PLANNING BOARD REPORT PORTLAND, MAINE

Studios at 46 Market Street
46 Market Street
Level III Site Plan and Subdivision Review
2013-245
Market Milk Partners, LLC, Applicant

Submitted to: Portland Planning Board Public Hearing Date: November 26, 2013 Planning Board Report Number: #55-13	Prepared by: Nell Donaldson, Planner Date: November 21, 2013 CBLs: 32-E-10001
-------------------------------------------------------------------------------------------------------------------------	-------------------------------------------------------------------------------------

Drawing file: 1_28_14 revisions / Sidewalk & Warning Pad details.pdf

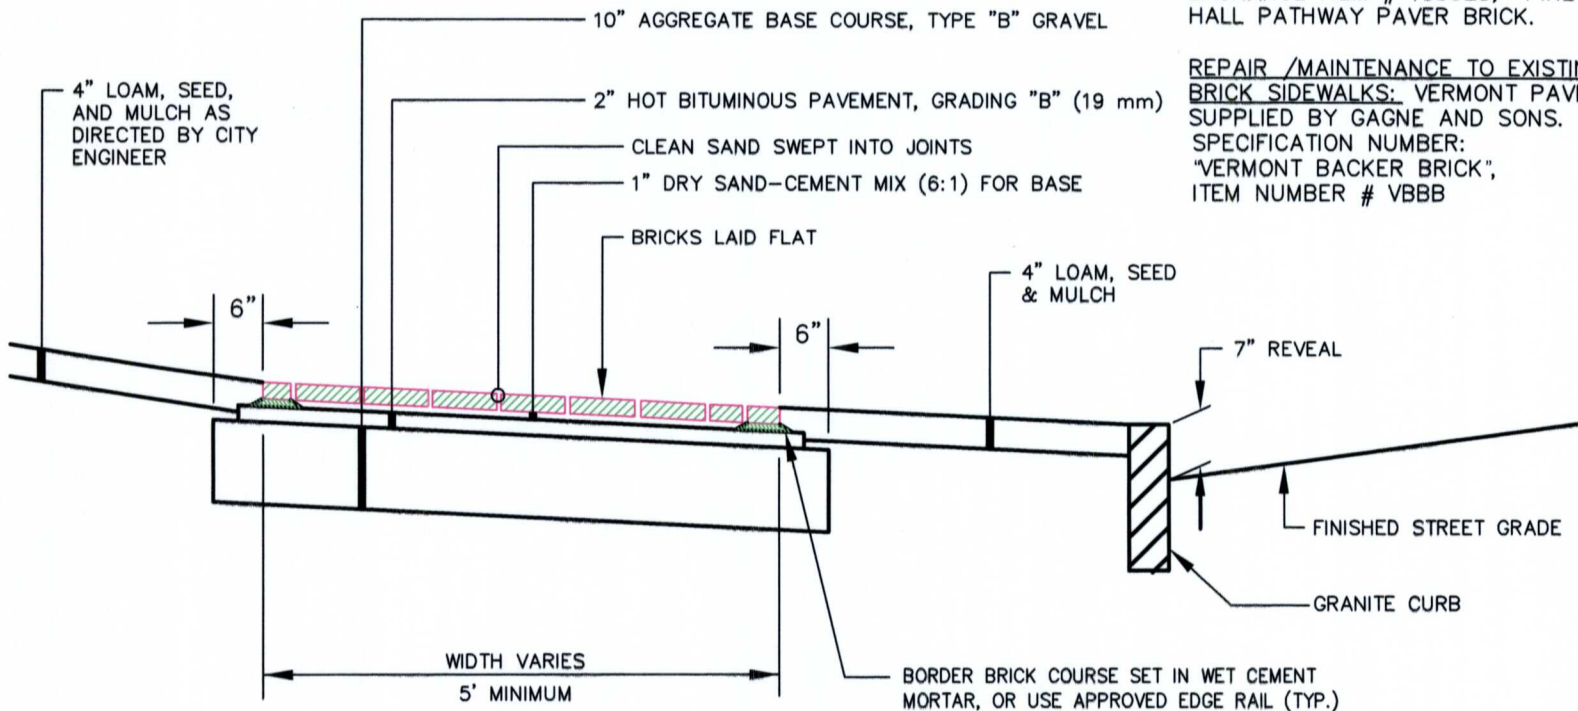
1. The applicant is requested to re-build the sidewalk ramp at the corner of Milk and Market Streets installing a detectable warning panel for the historic district per Figure I-7A on page 40 of the City's Technical Manual. The applicant is also request to install a short section of flush granite curb in conjunction with this ramp. The City may have a piece of granite curbing stored on outer Congress St which may be used at no cost to the applicant except to pick up and transport. The applicant is requested to use the Pinehall Pathway Pavers bricks when rebuilding this ramp.

2. There are two potential tripping areas in the Market St. sidewalk adjacent to sidewalk ramp. One next to the building corner and the other around the catchbasin headstone. The applicant is requested to remove the brick as necessary in these two areas and reconstruct as necessary to eliminate these tripping hazards. Again, the City may have bricks at the outer Congress Street storage area which will match the existing brick. The applicant is welcome to use these brick as necessary to facilitate these repairs.

2. The applicant shall provide plans, stamped by a licensed engineer and including details, depicting:
 - a. the reconstruction of the ramp at Milk and Market Streets to include a standard detectable warning panel and flush granite curb, and

- b. the reconstruction of areas of sidewalk on Market Street to eliminate tripping hazards for review and approval by the city's Department of Public Services and Planning Authority;
